Subject: RE: 14-136 Pearl Dental, Angmering

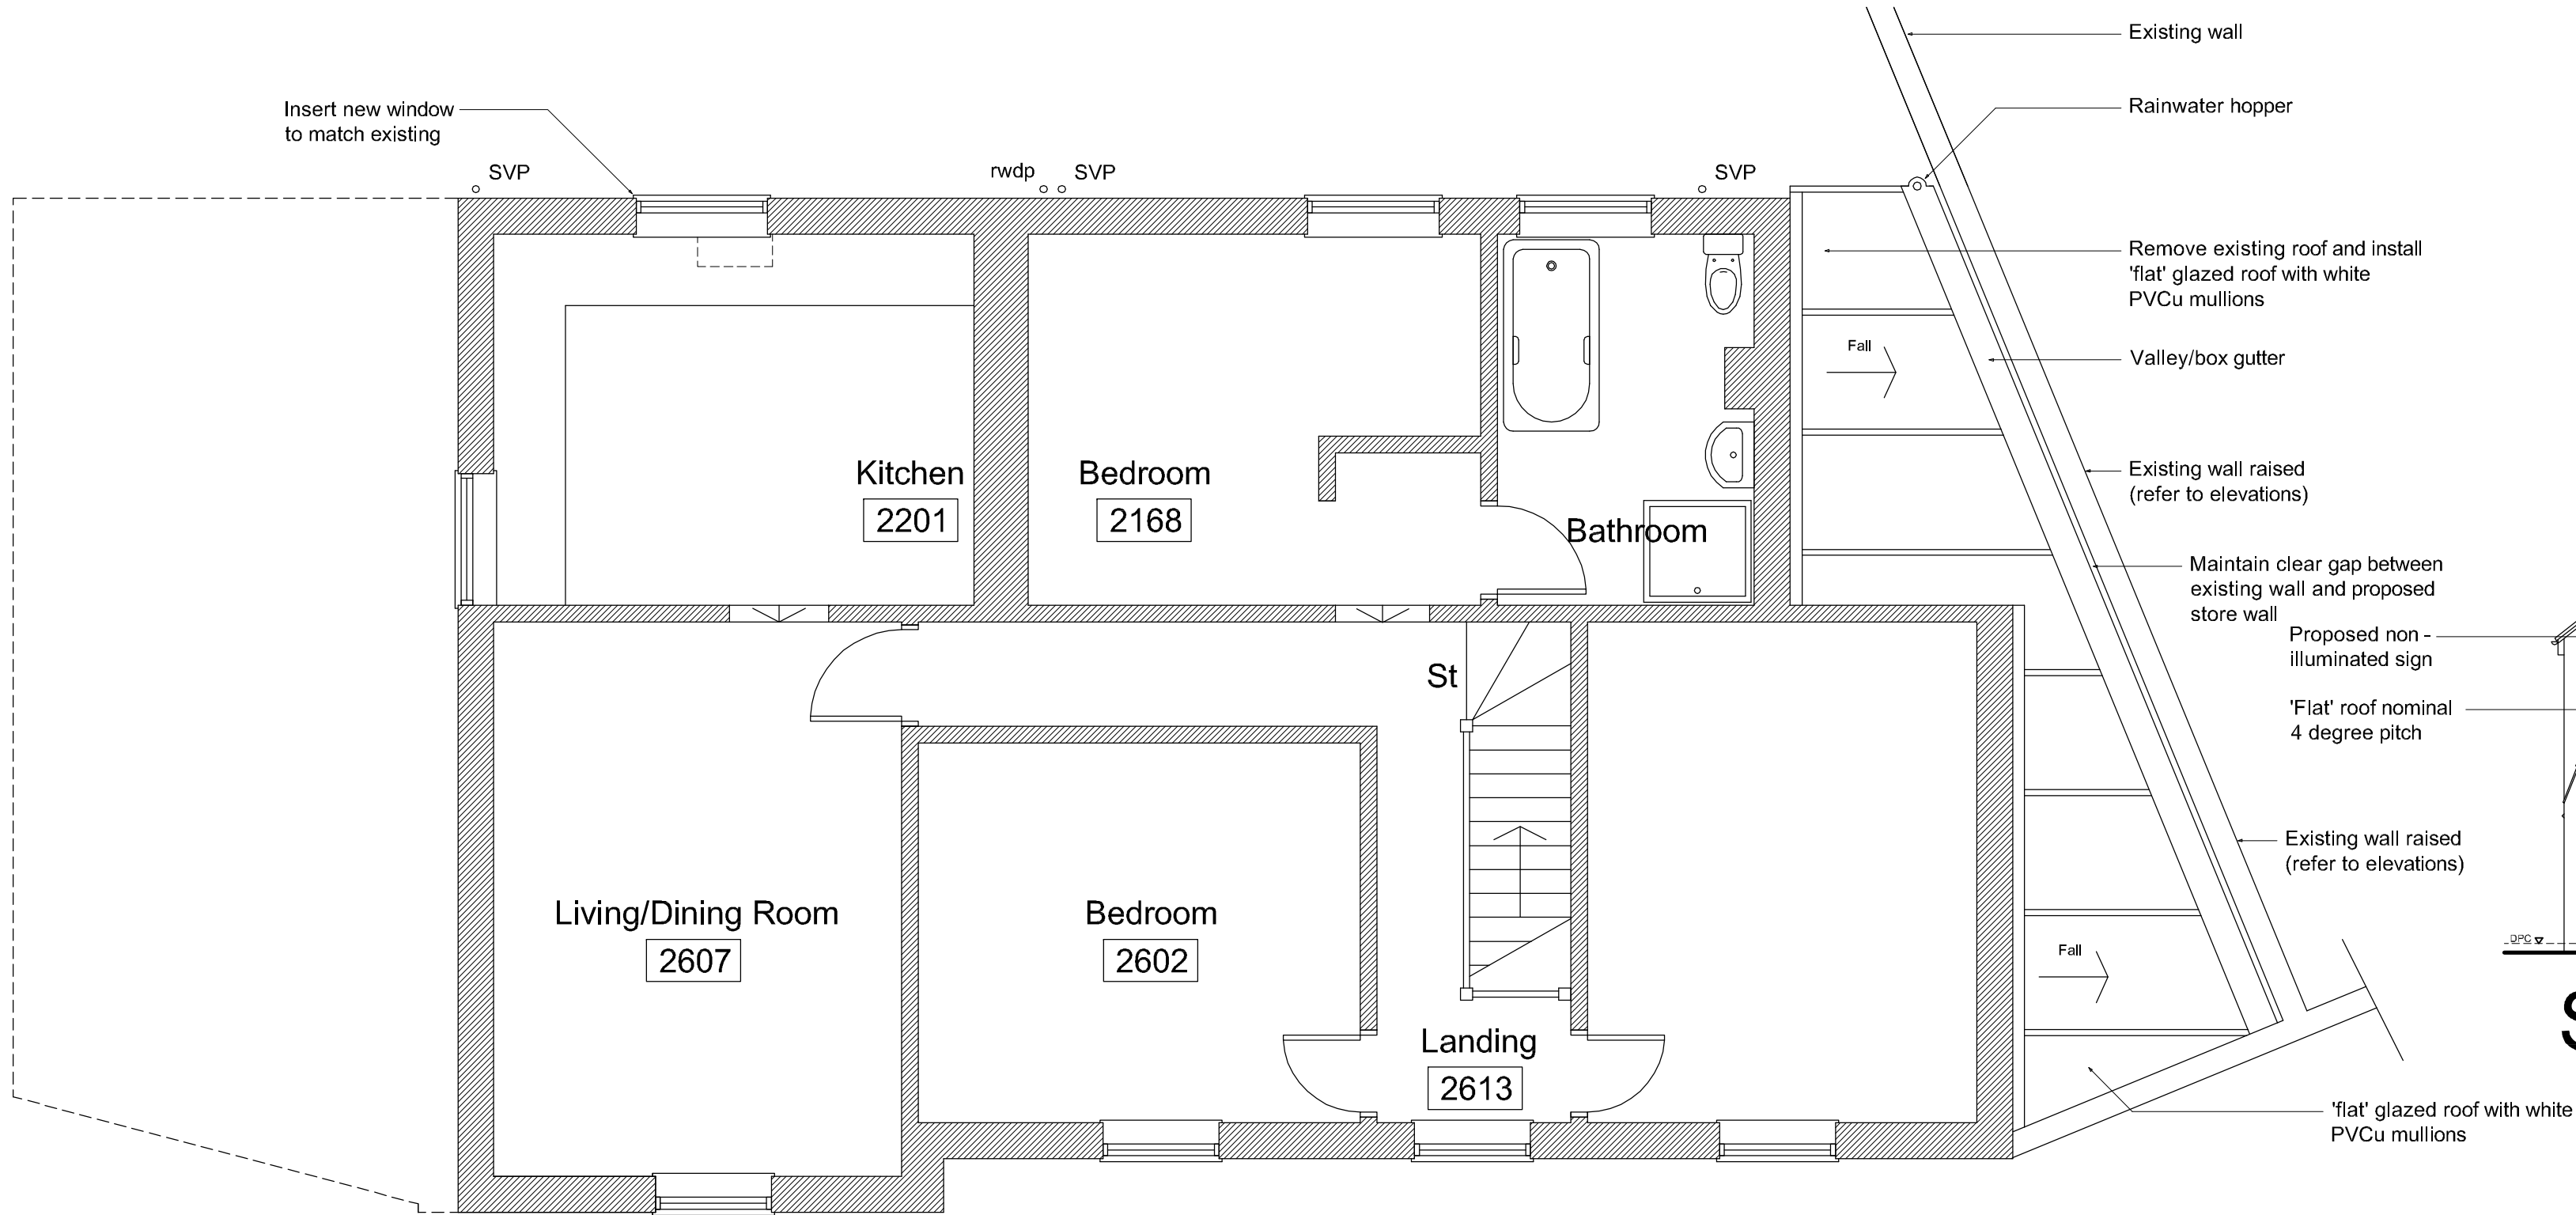
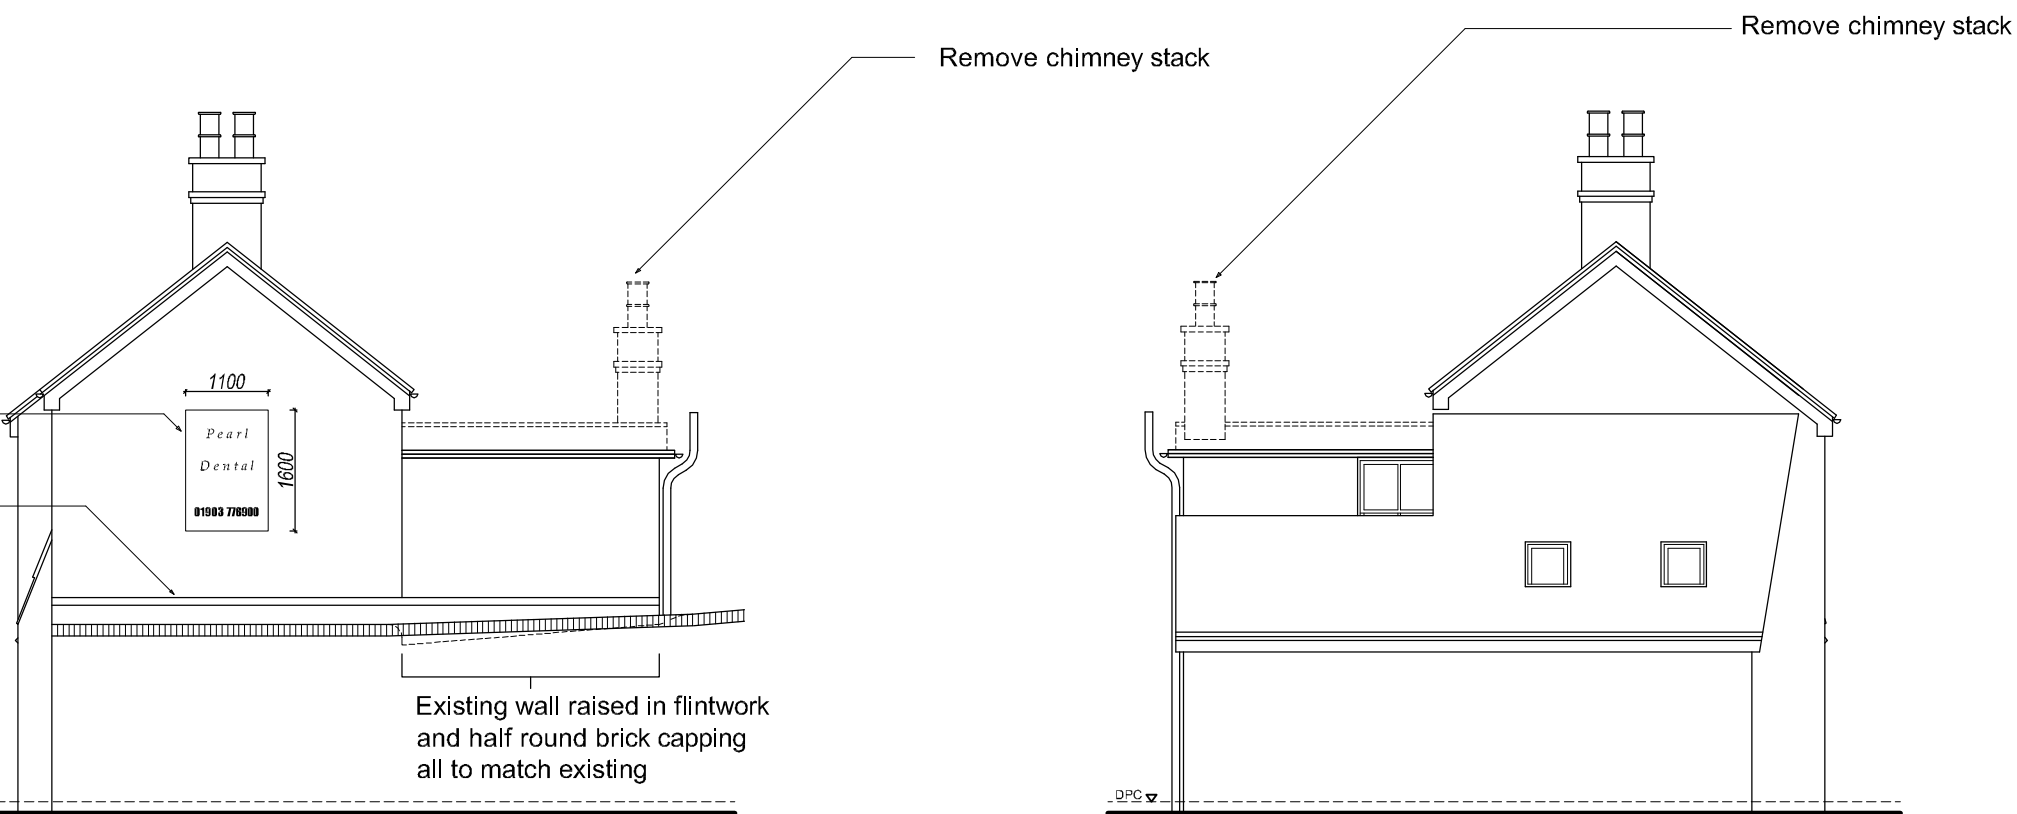
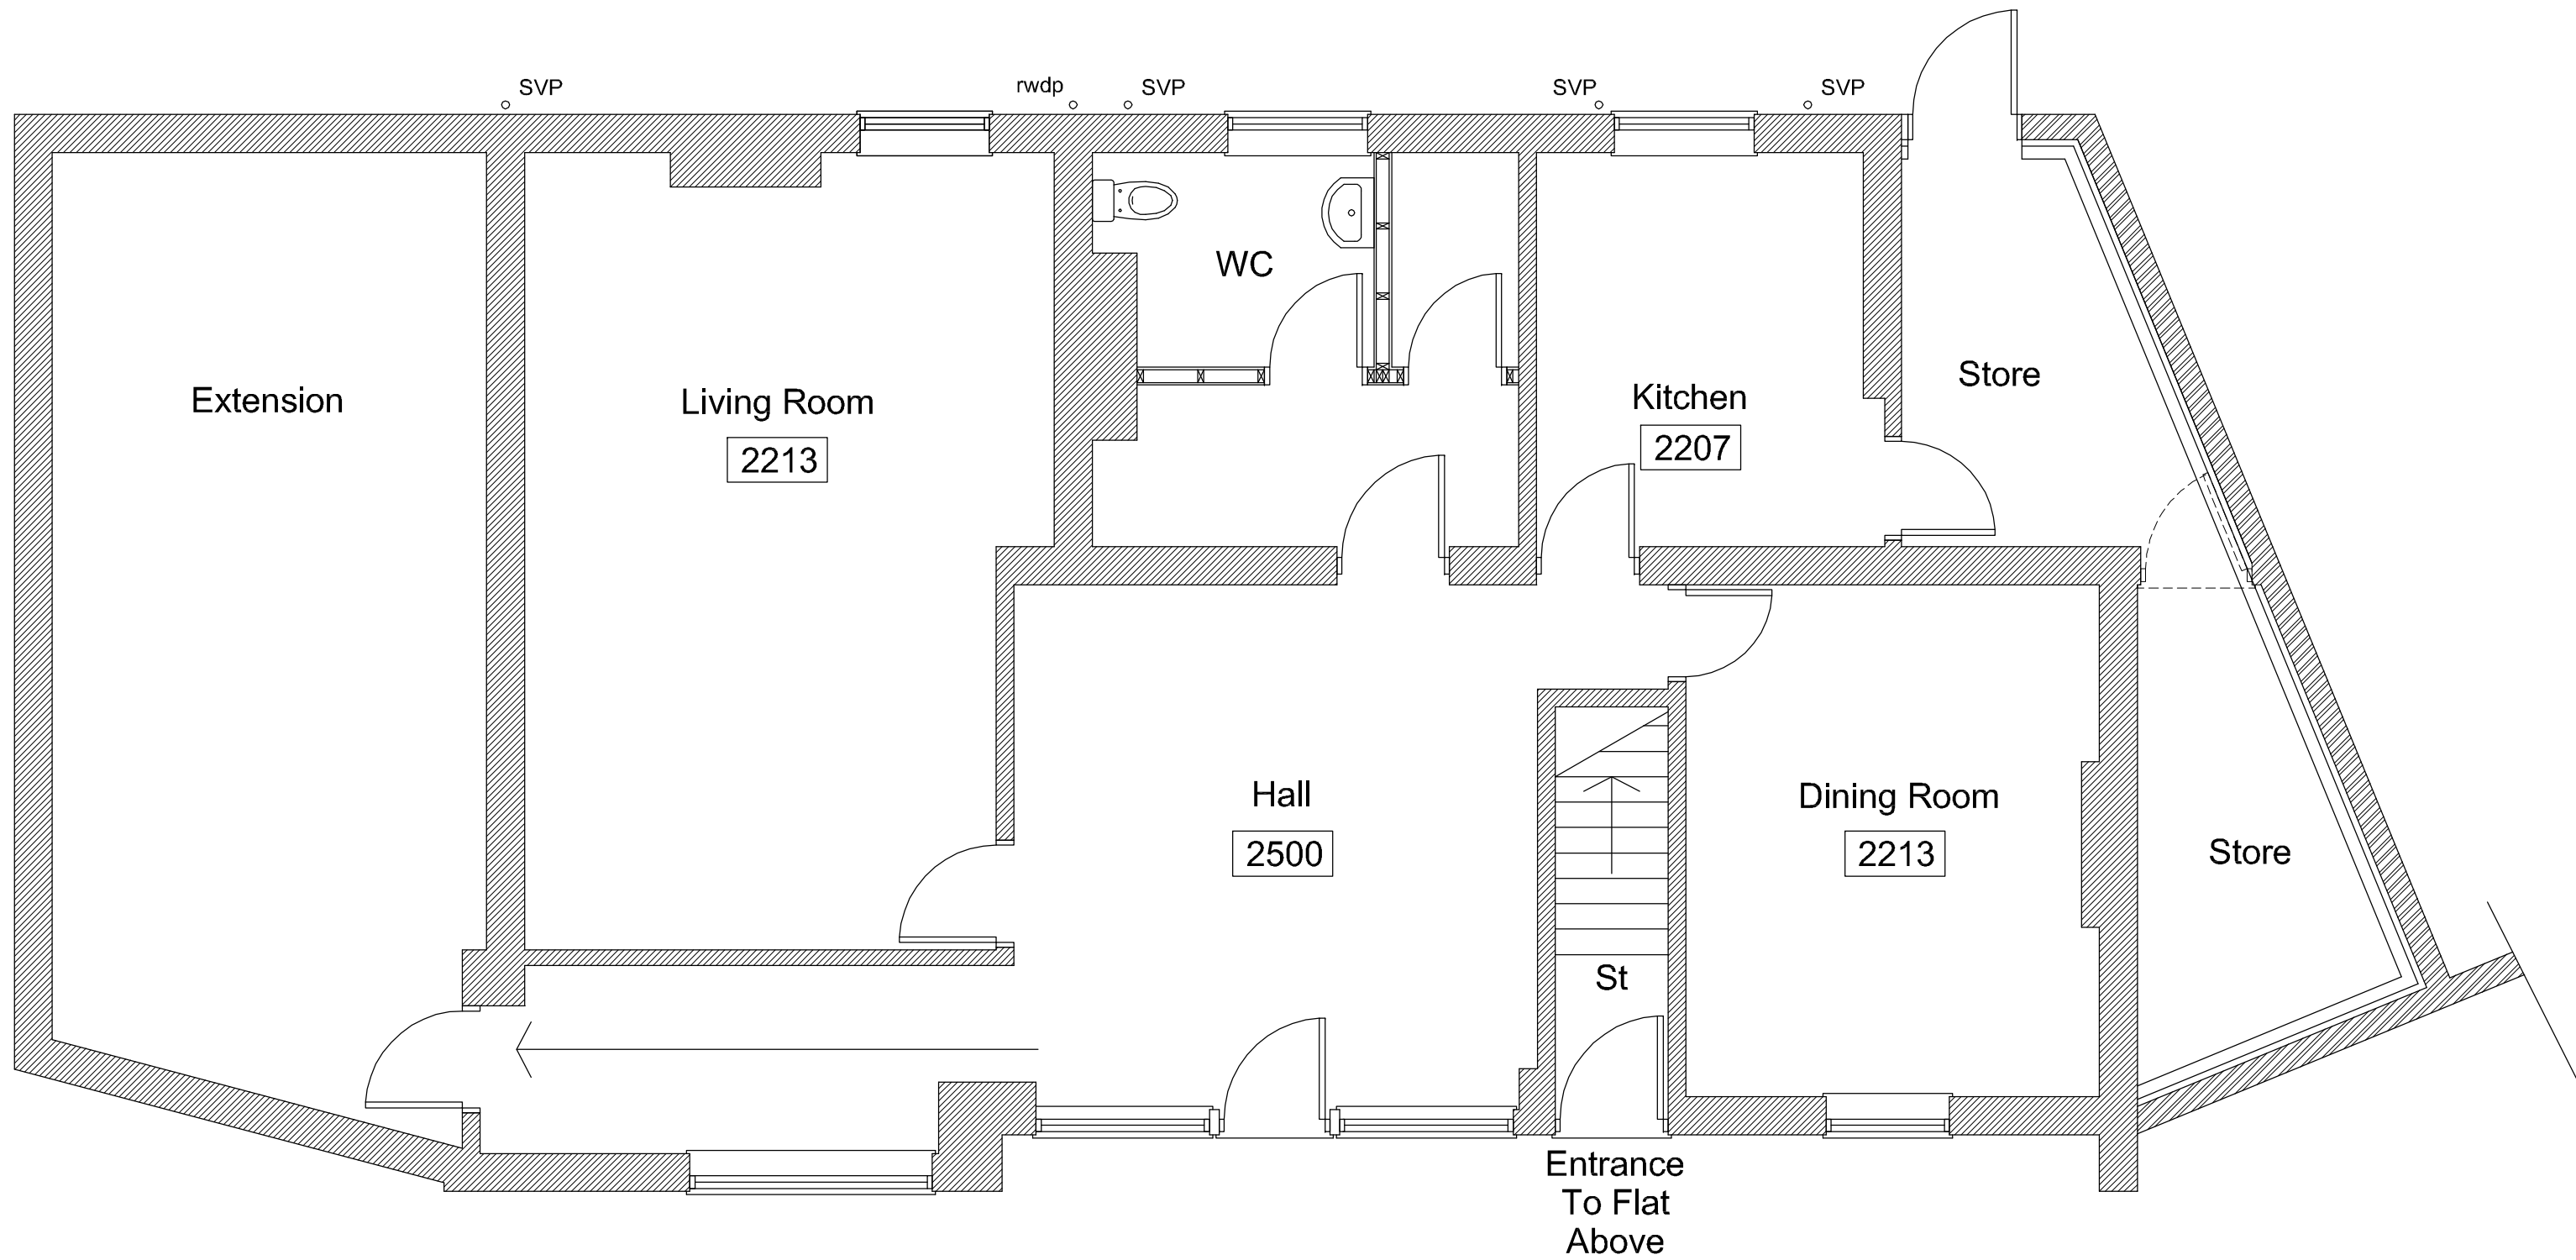
I will be honest and state that I still have reservations regarding the loss of the valley. However, you are able to explain the reasons for the proposal and your belief in the lack of impact as part of the application. The use of quality materials may lessen the impact of the change.

The signage does seem excessive. However, the impact of the front sign could be reduced if the existing sign is to be removed.
